Our Ref: R/296/19/HH

**Town & Country Planning Act 1990 (as amended)
Town & Country Planning (Development Management Procedure) (England) Order 2015
Application for Planning Permission for Works or Extension to a Dwelling**

Development Single storey side extension
Location 21 Merton Avenue Rustington

DRW NO 7 SCALE 1/500
SITE PLAN

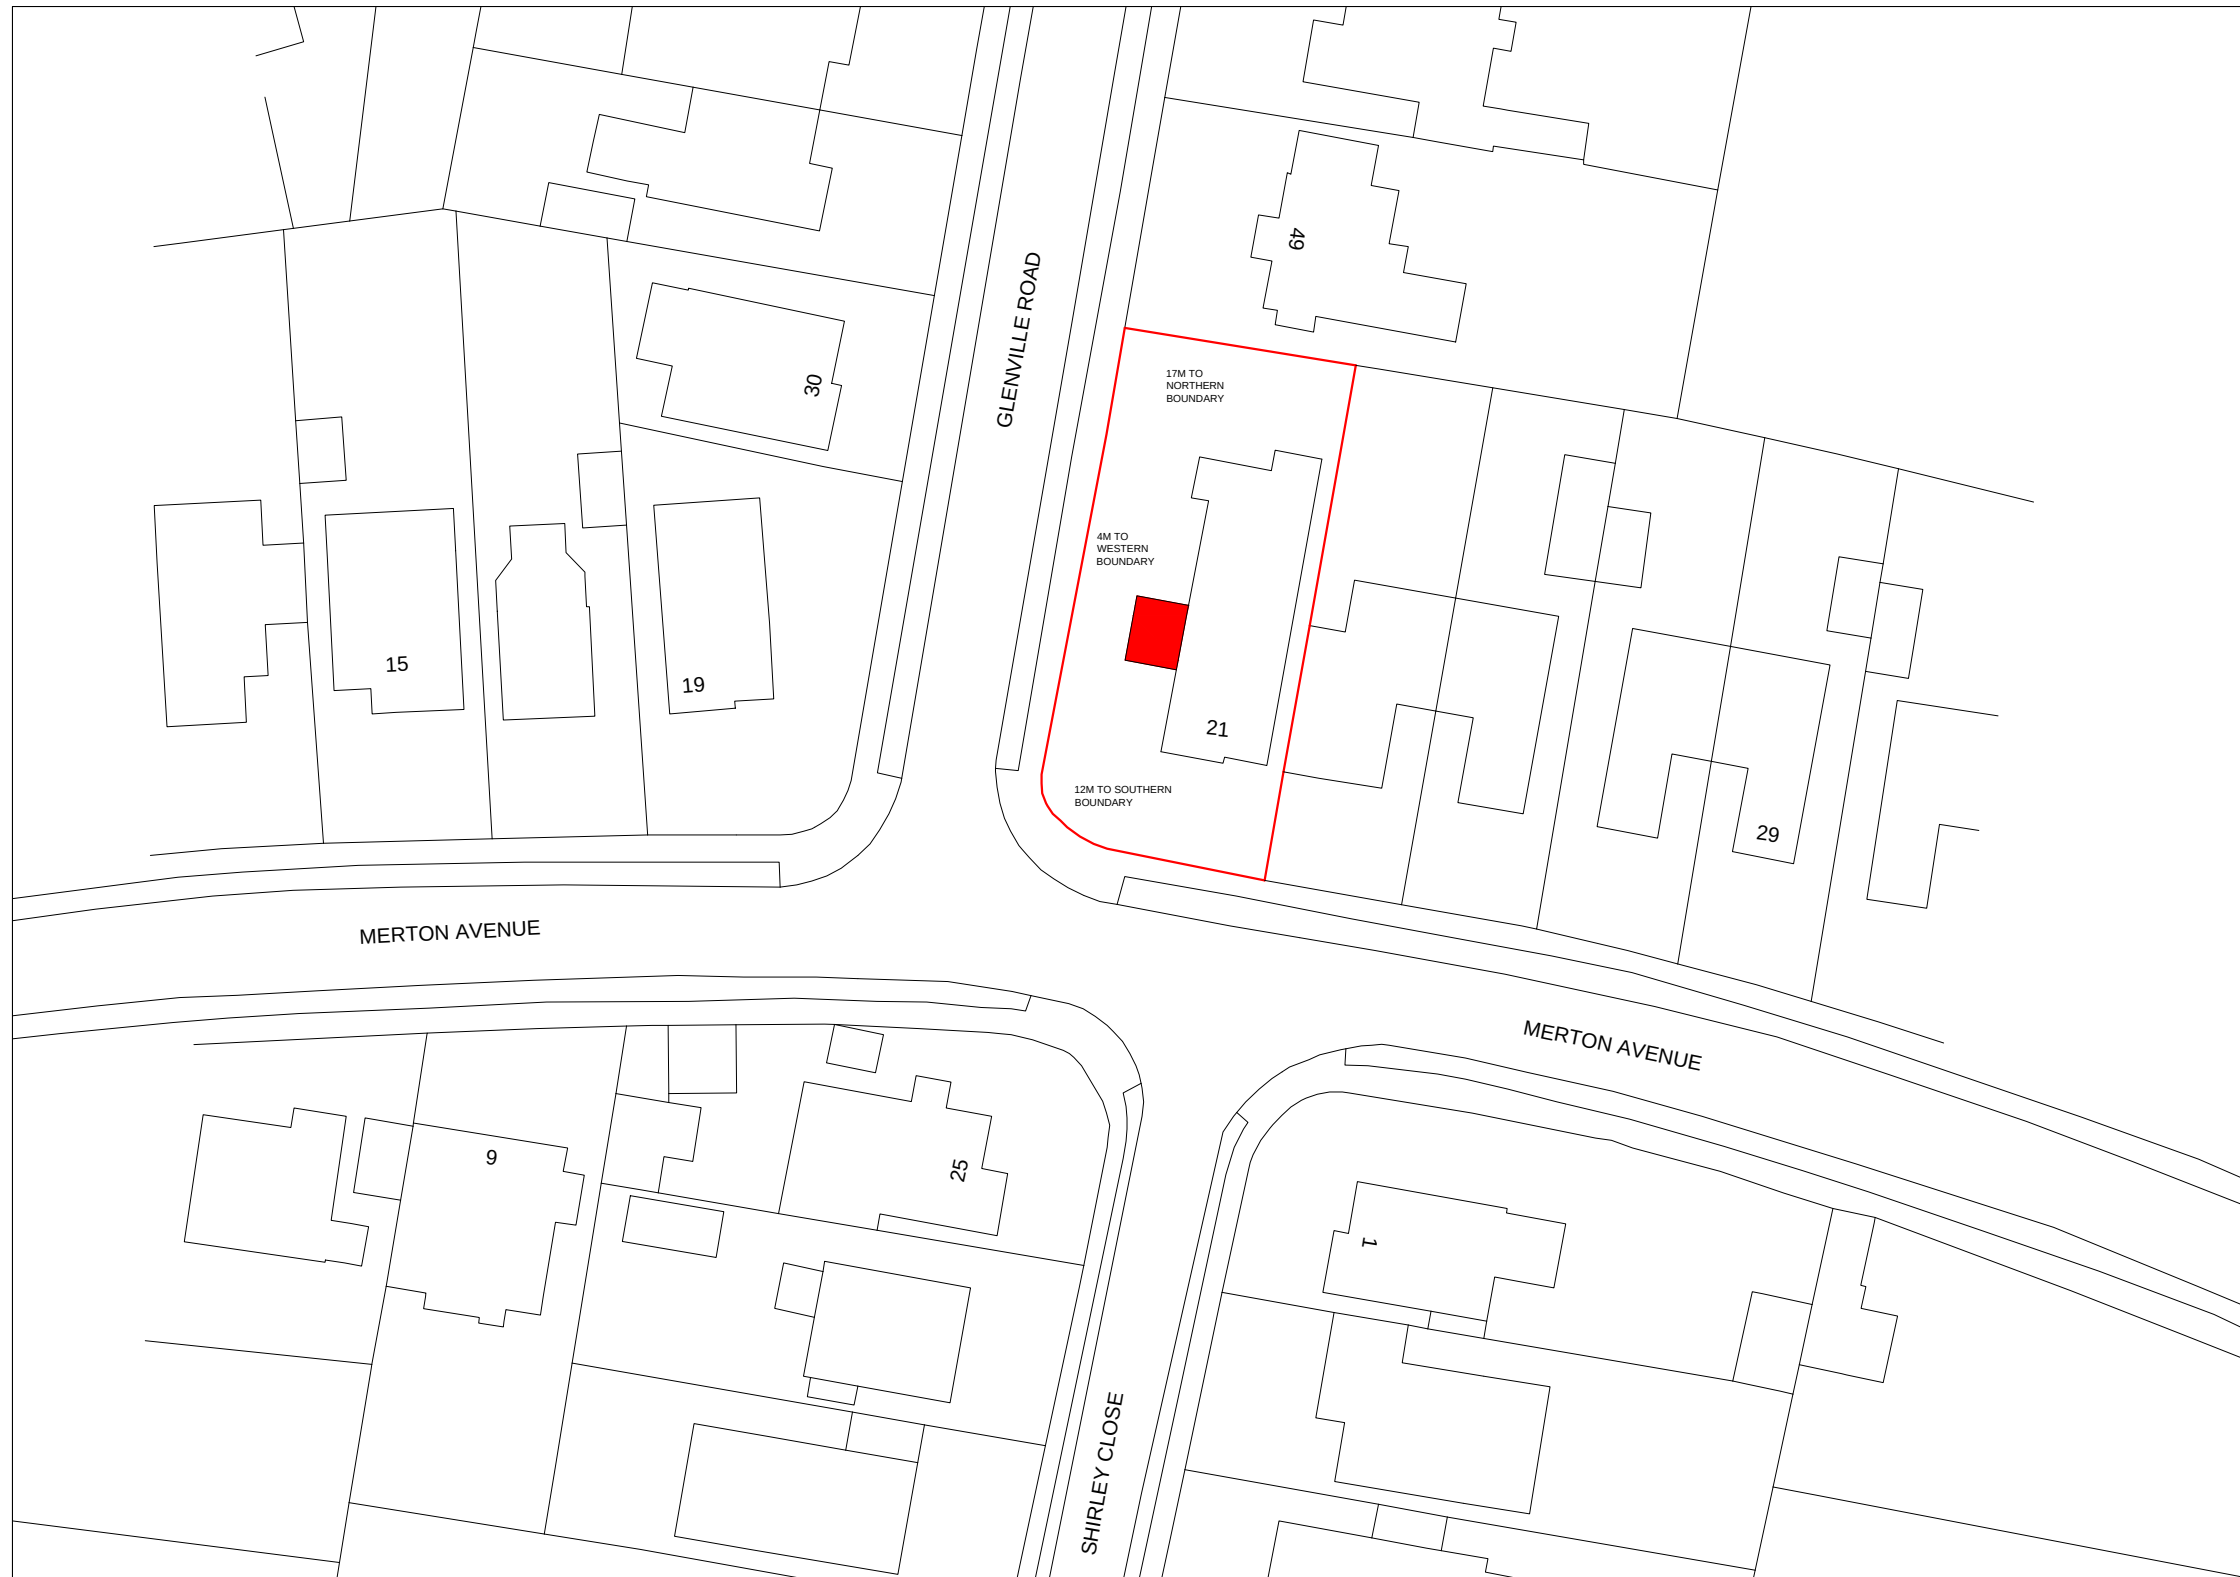
Block Plan: It is a local requirement that dimensions are included from the proposed extension to all site boundaries. Please amend.

Michael Pearce & Associates Ltd Chartered Surveyors - Architectural Consultants 47 Sea Lane Gardens, Ferring. West Sussex. BN12 5EQ.	CONSERVATORY EXTENSION 21 MERTON AVENUE, RUSTINGTON. BN16 2EQ.	DRW NO 2 SCALE 1/100 PROPOSED GROUND FLOOR PLAN
--	--	--	--

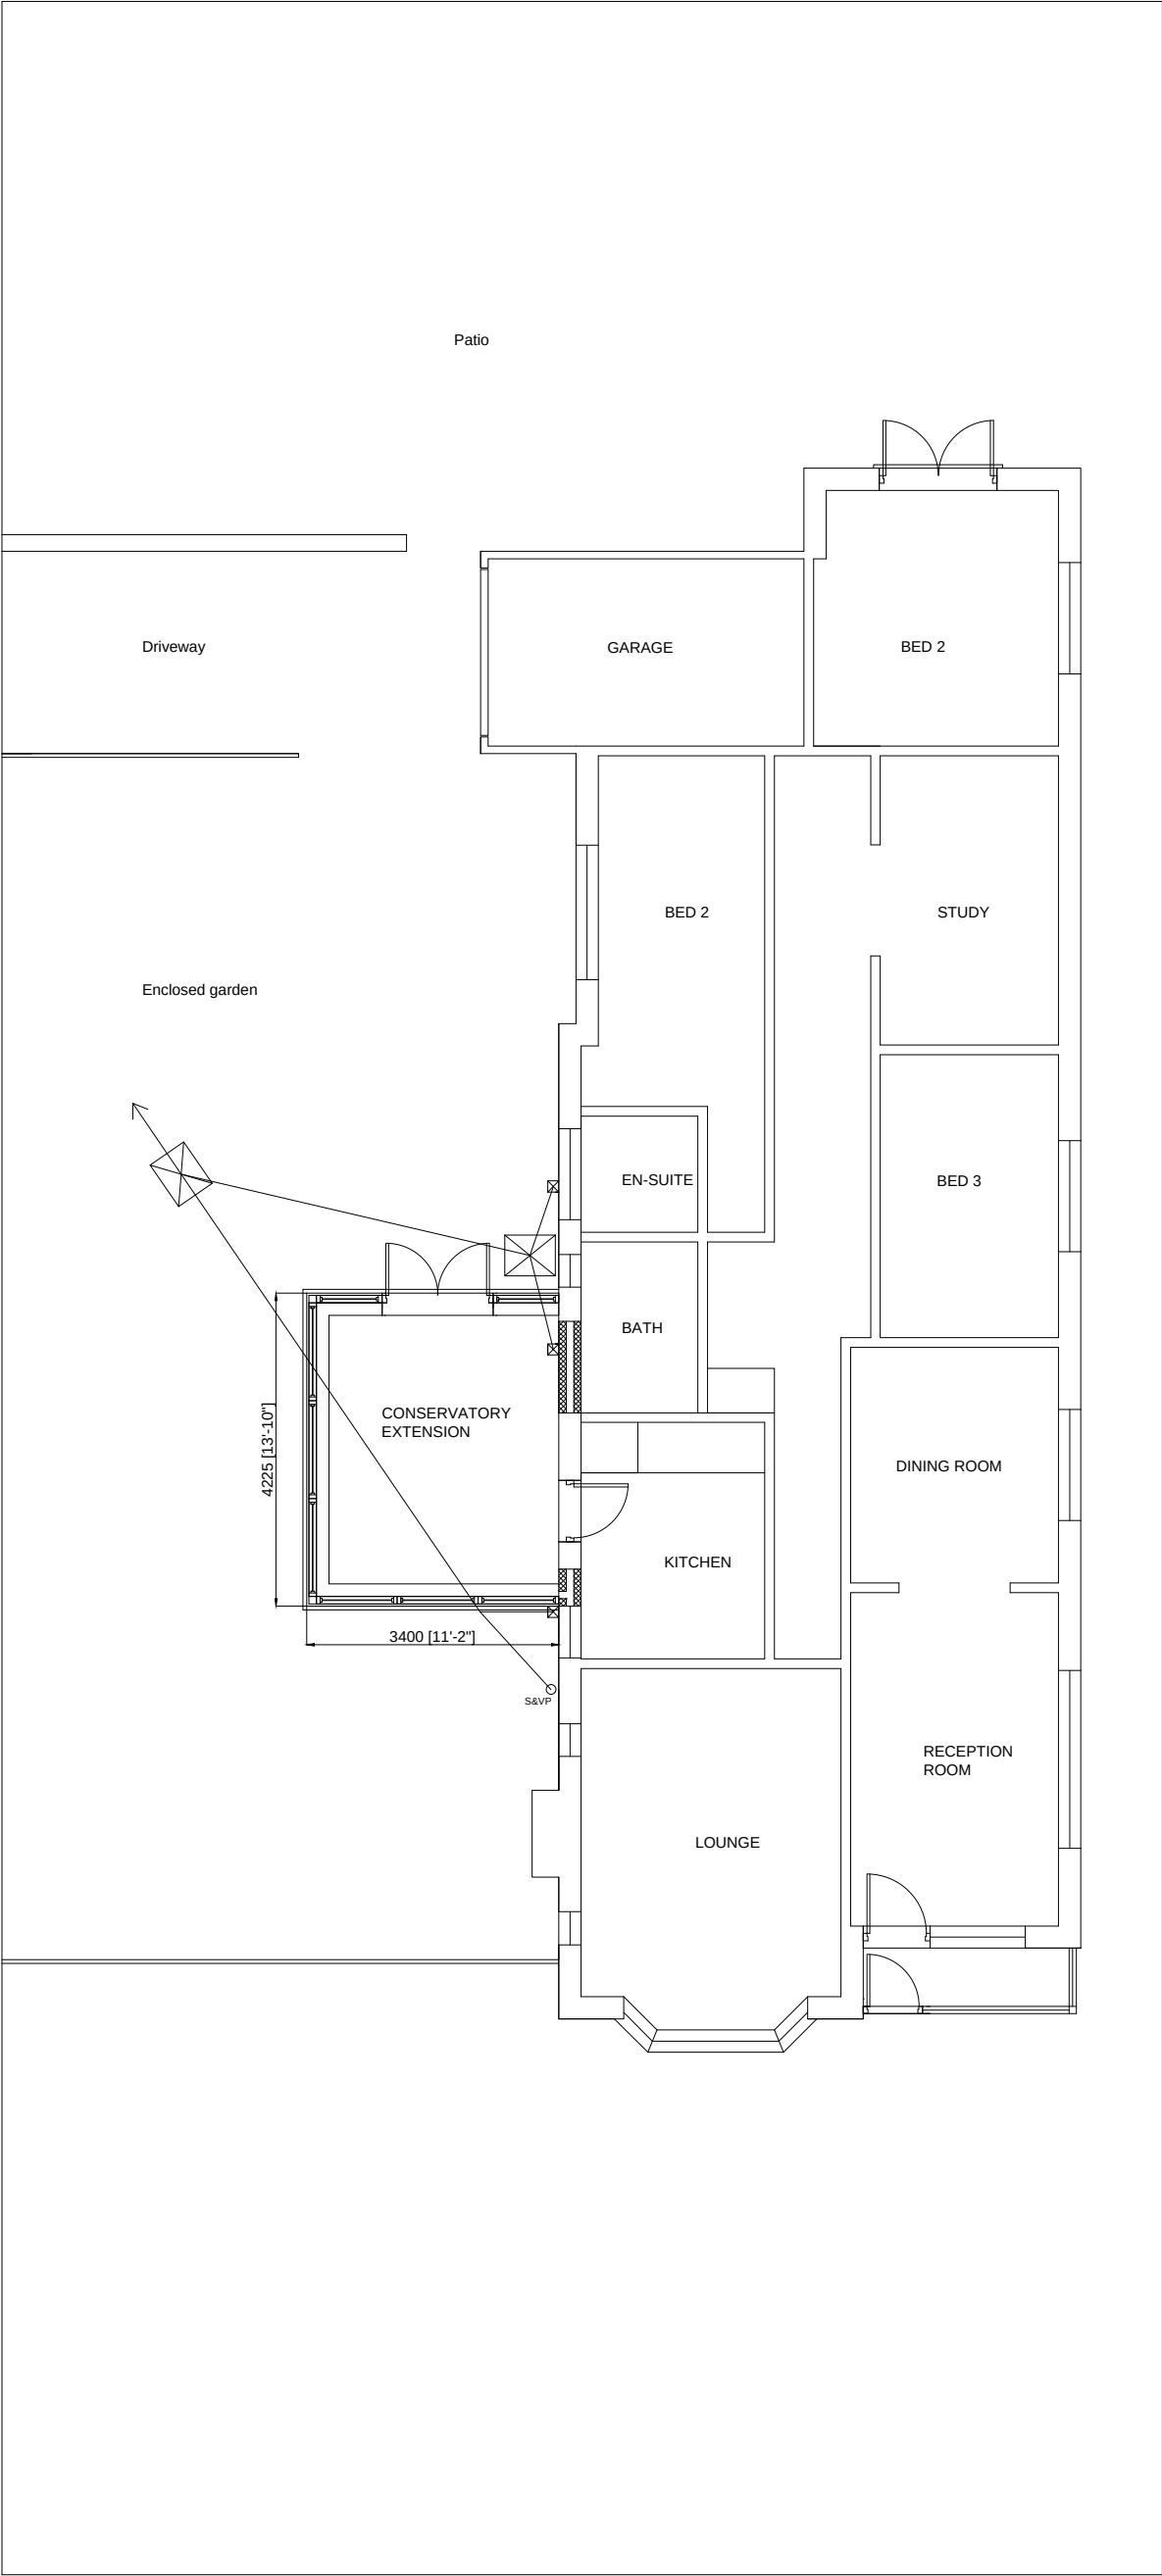
Plans Inconsistent: The door is inconsistent between the proposed floor plan and proposed rear elevation.
